From: Dan Thompson <danielphompson@hotmail.com>
Sent: Thursday, March 16, 2023 2:34 PM
To: Ryan Harriman
Cc: Suzanne Skone; Mike or Susie Cero; Carv Zwingle; fletchsa1@gmail.com; Thomas Acker; Council; Traci Granbois; Robert Medved; Jessi Bon
Subject: Public Comments SUB 19-002/Boys and Girls Club Long Subdivision

2/16/23
 JOB NUMBER:
13-118
 SHEET NAME:
CV-01
 SHT 1 OF 9

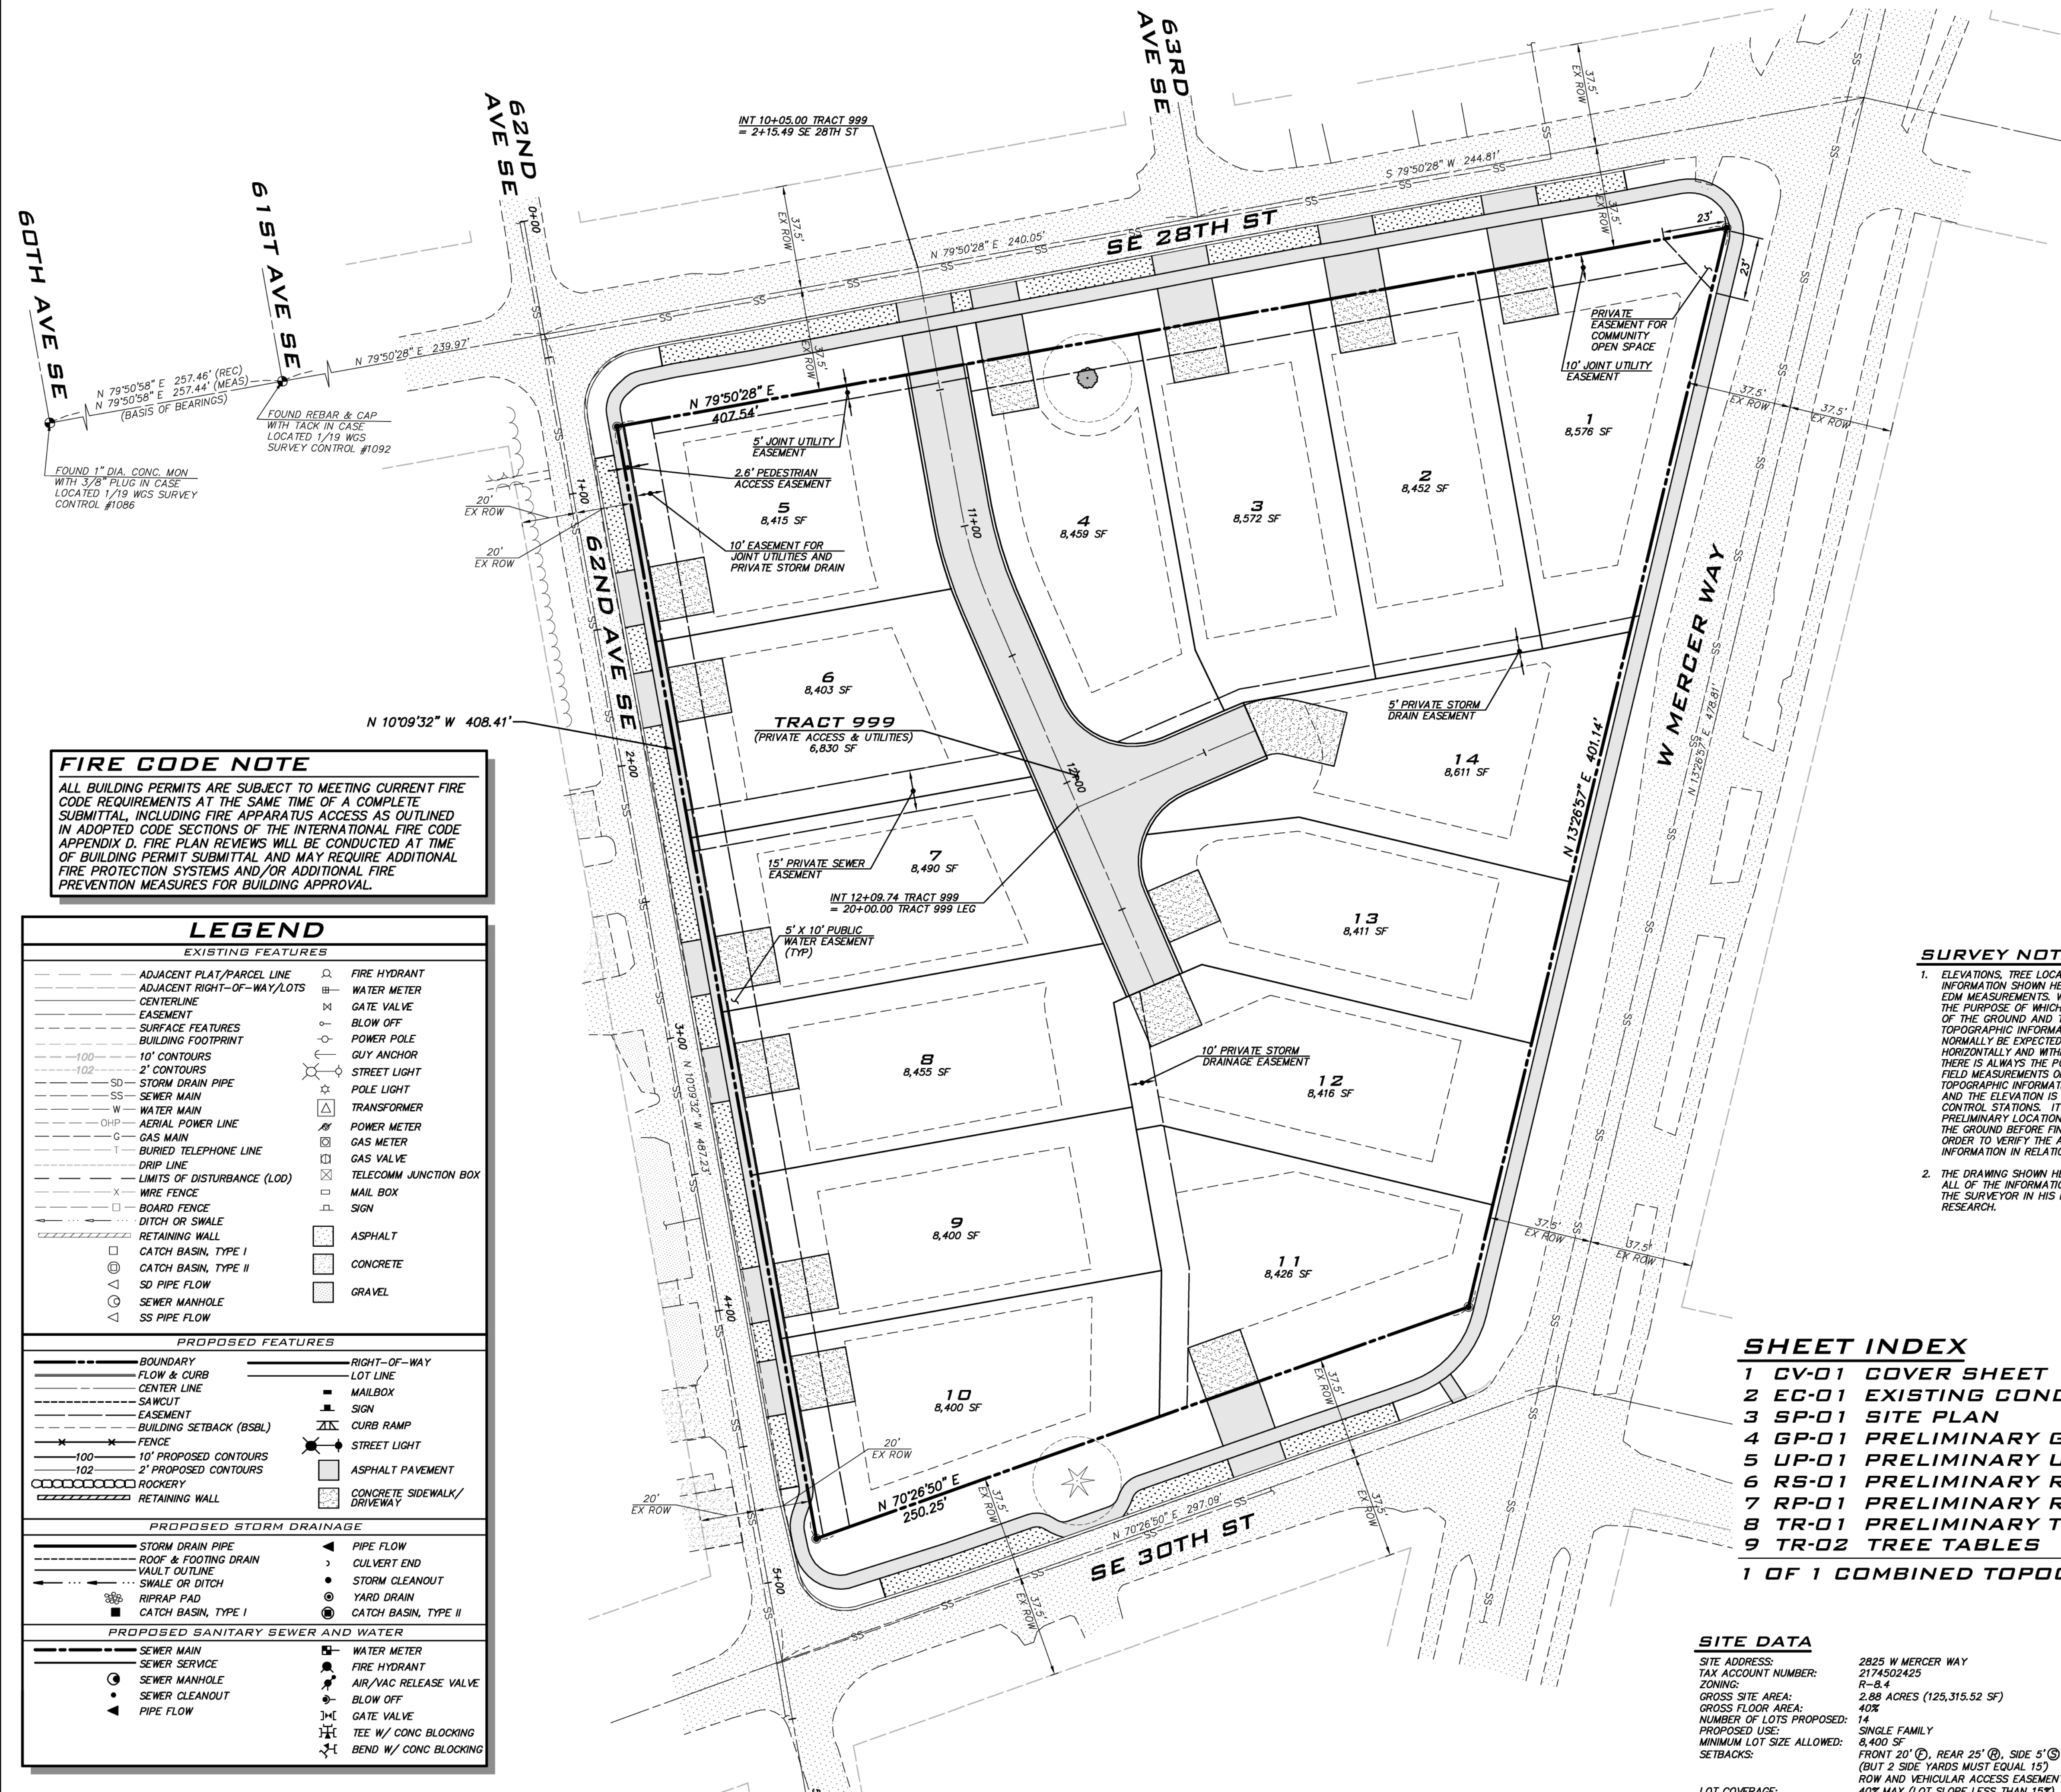
A. There is no green space at all, despite the demolition of an historical building and removal of many mature trees. I believe some green space setaside should be required as in the original plans although it reduced the total number of lots from 14 to 13.

My belief is the MICC requires the applicant to set aside an area equal to one lot for green space, and all access should be by internal roads. These are the same findings Evan Maxim made if you review his file, and were the findings of the council in the Coval long plat process.

2/16/23
 JOB NUMBER:
13-118
 SHEET NAME:
SP-01
 SHT **3** OF **9**

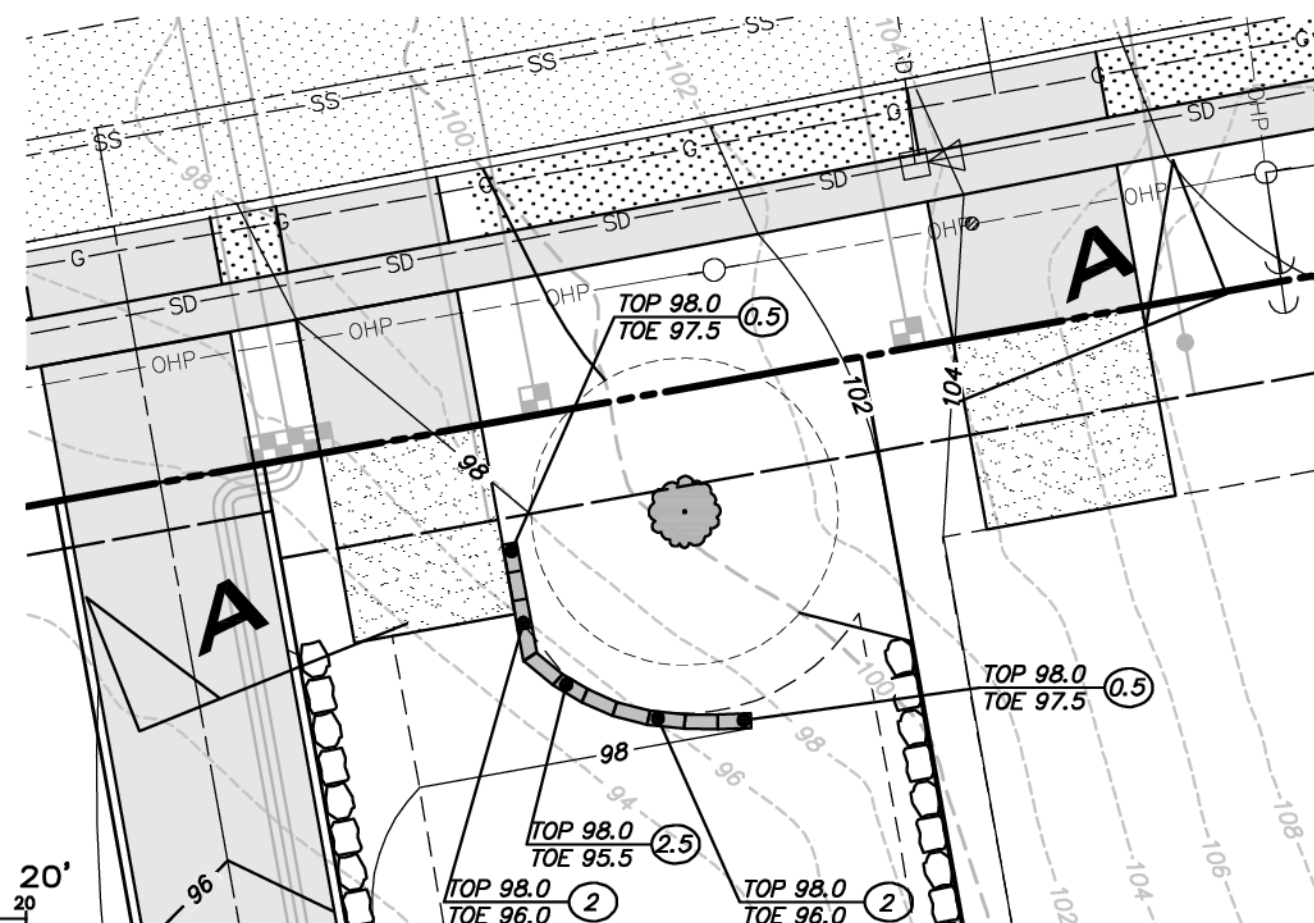
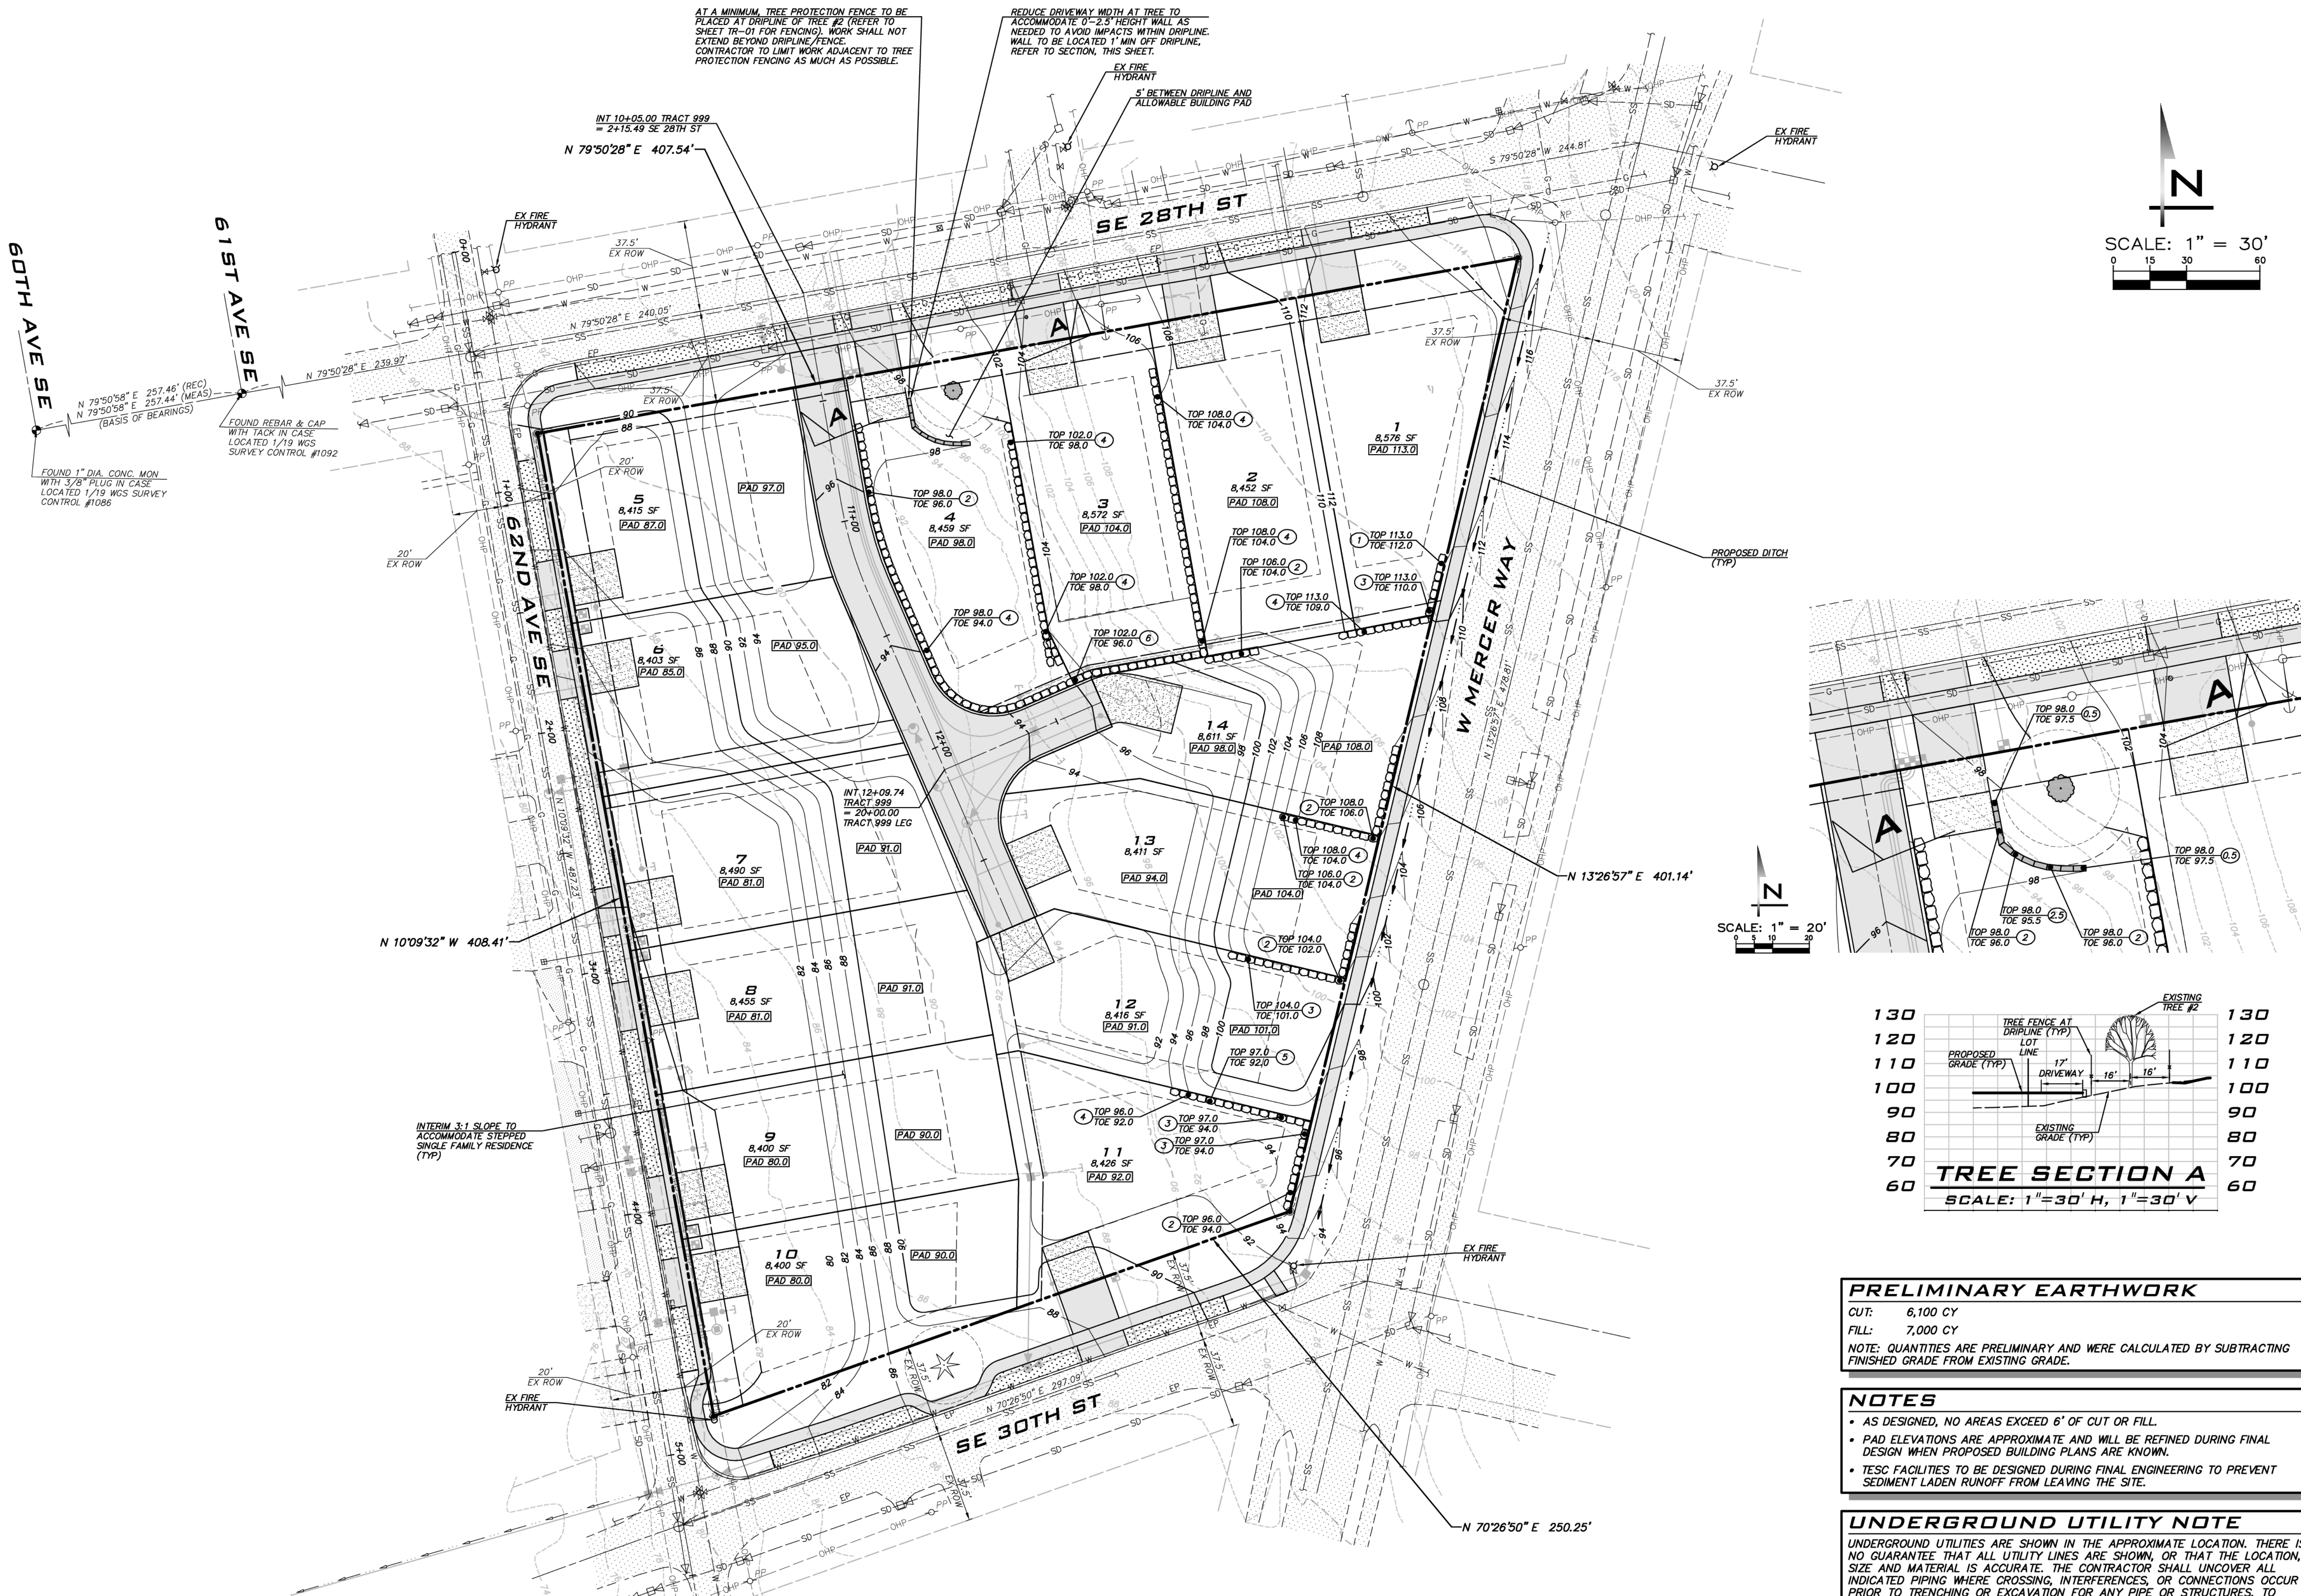
B. Ingress and egress should be by internal road for each house. The applicant no doubt does not like this since the internal road counts against lot area and lot coverage limits, but in my opinion the current plans are a danger to those walking or biking along adjacent streets. There is some internal access to some lots, but all access should be by an internal access road.
